DEVELOPMENT HEARING OFFICER

TRANSPORTATION DEVELOPMENT

Project Number: 2025-020092
Valiente B/W PDN-Kimmick

SUBJECT: Preliminary Plat

Plat for
Lots 1A-1-A, 1A-1-B, 4A-1-A, and
4A-1-B, Block 3, Volcano Cliffs
Subdivision, Unit 26
Being Comprised of
Lot 4A-1 and Portion of Lot 1A-1,
Block 3, Volcano Cliffs Unit 26
City of Albuquerque, Bernalillo County, New Mexico
October 2025

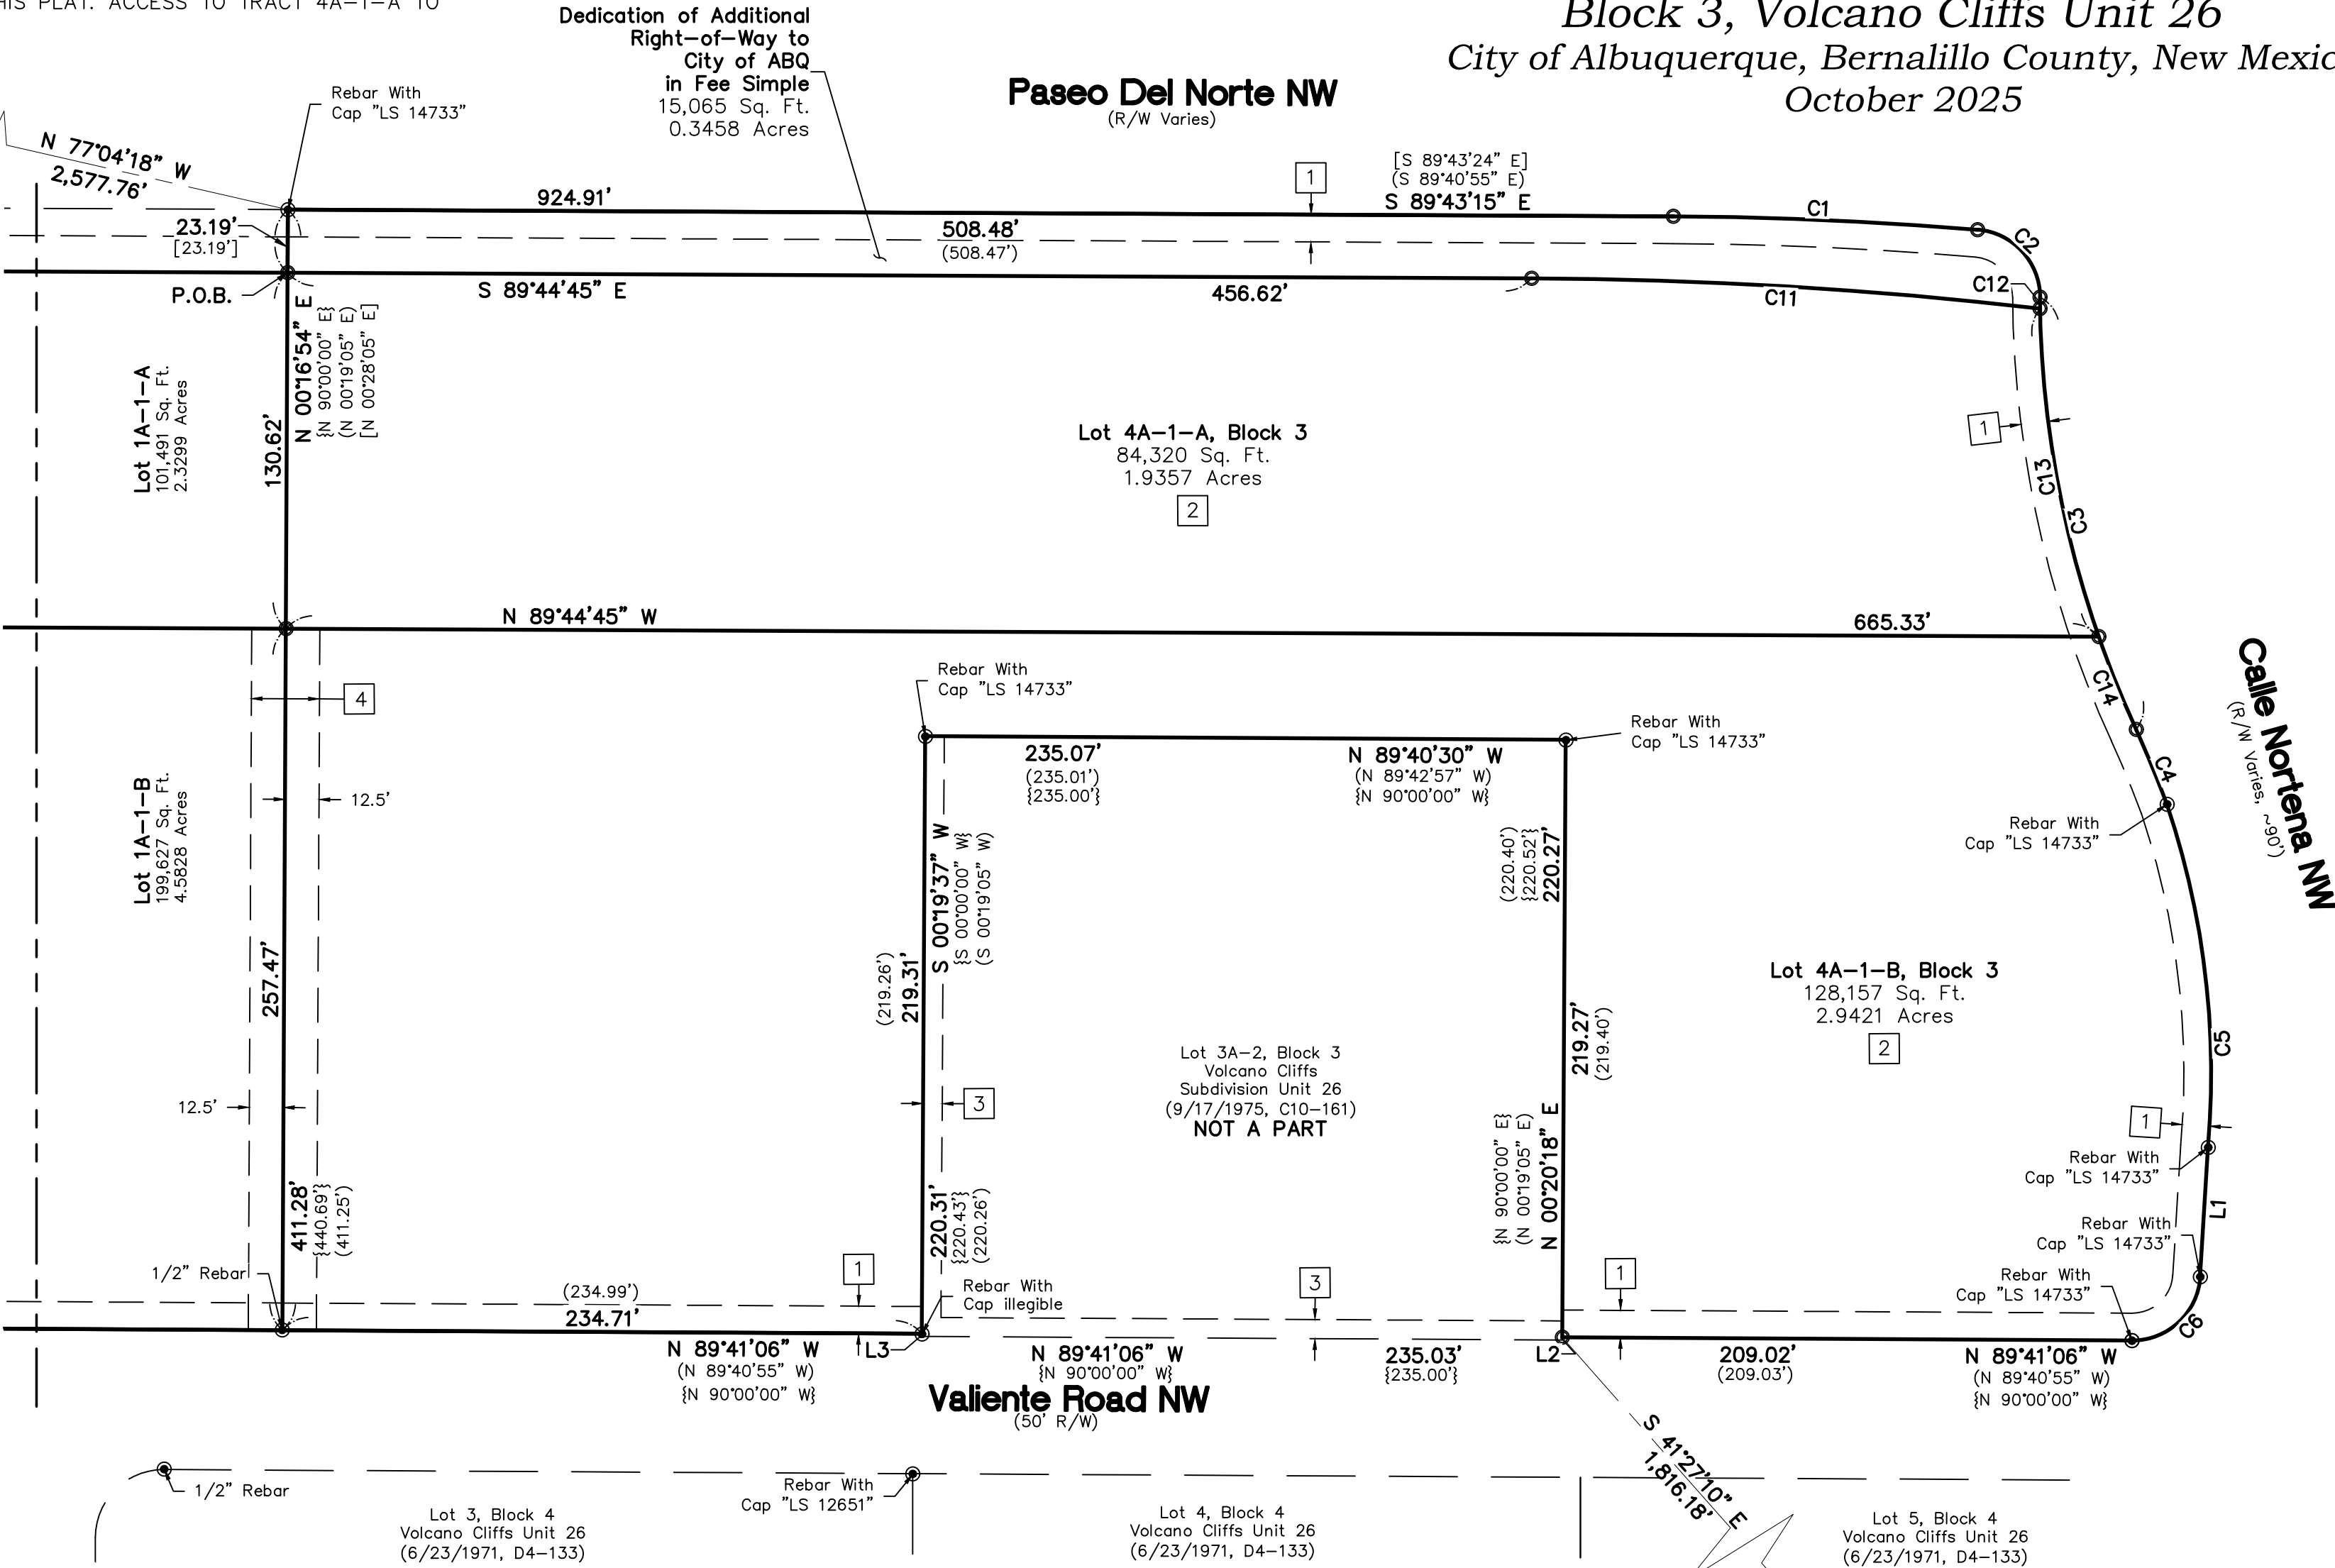
1. Paseo Del Norte is a Principal arterial requires 6 ft sidewalk, and 5-6 ft Landscape buffer. Even if this work is on a proposed City project this work needs to be on an infrastructure list and will most likely use procedure C.
